PLANNING AMENDMENT

Application No. H11/1109/02 MA1

EXTENSION & ALTERATIONS.

Amendment: Additional side elevation shown
447/01 01A

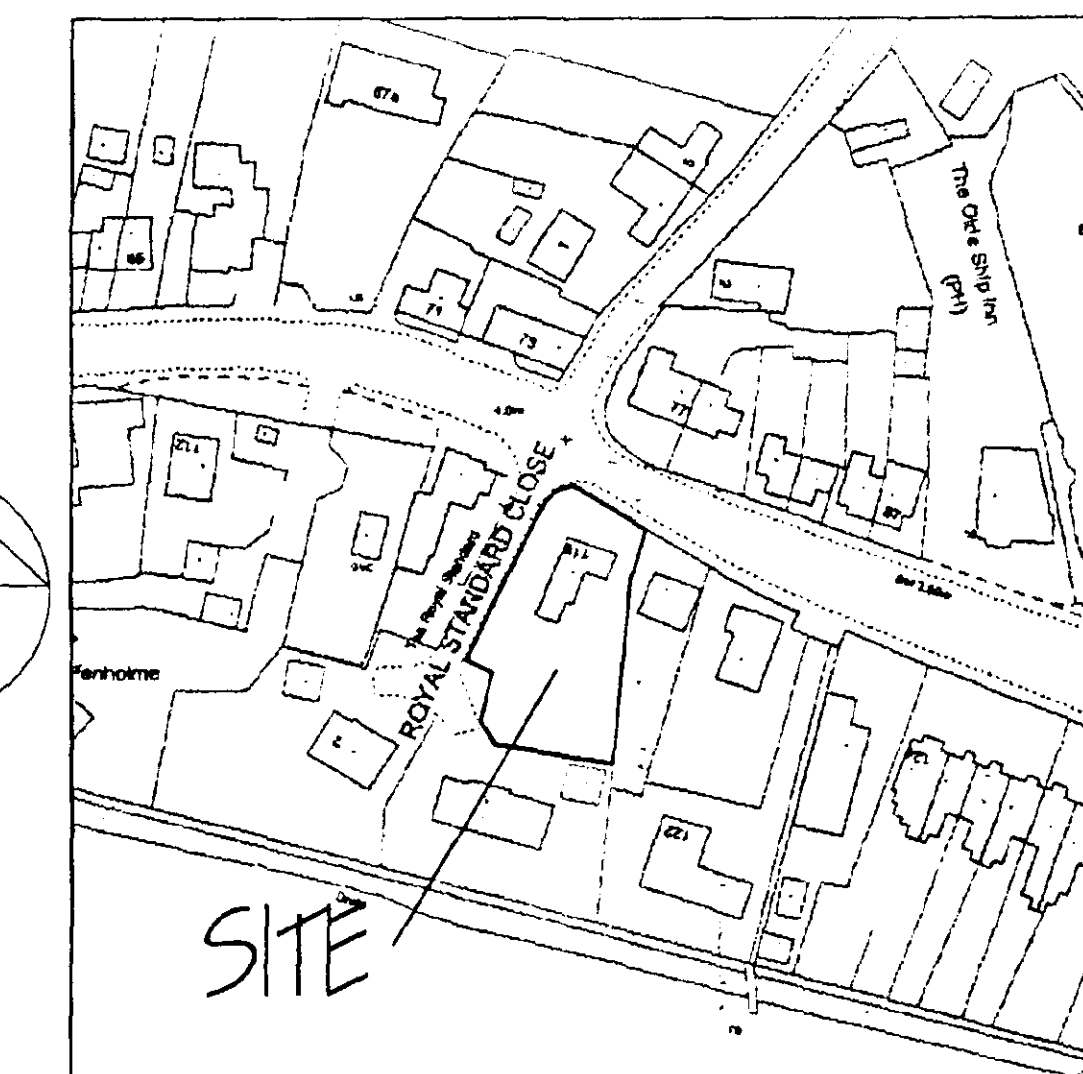
EAST ELEVATION ADDED.
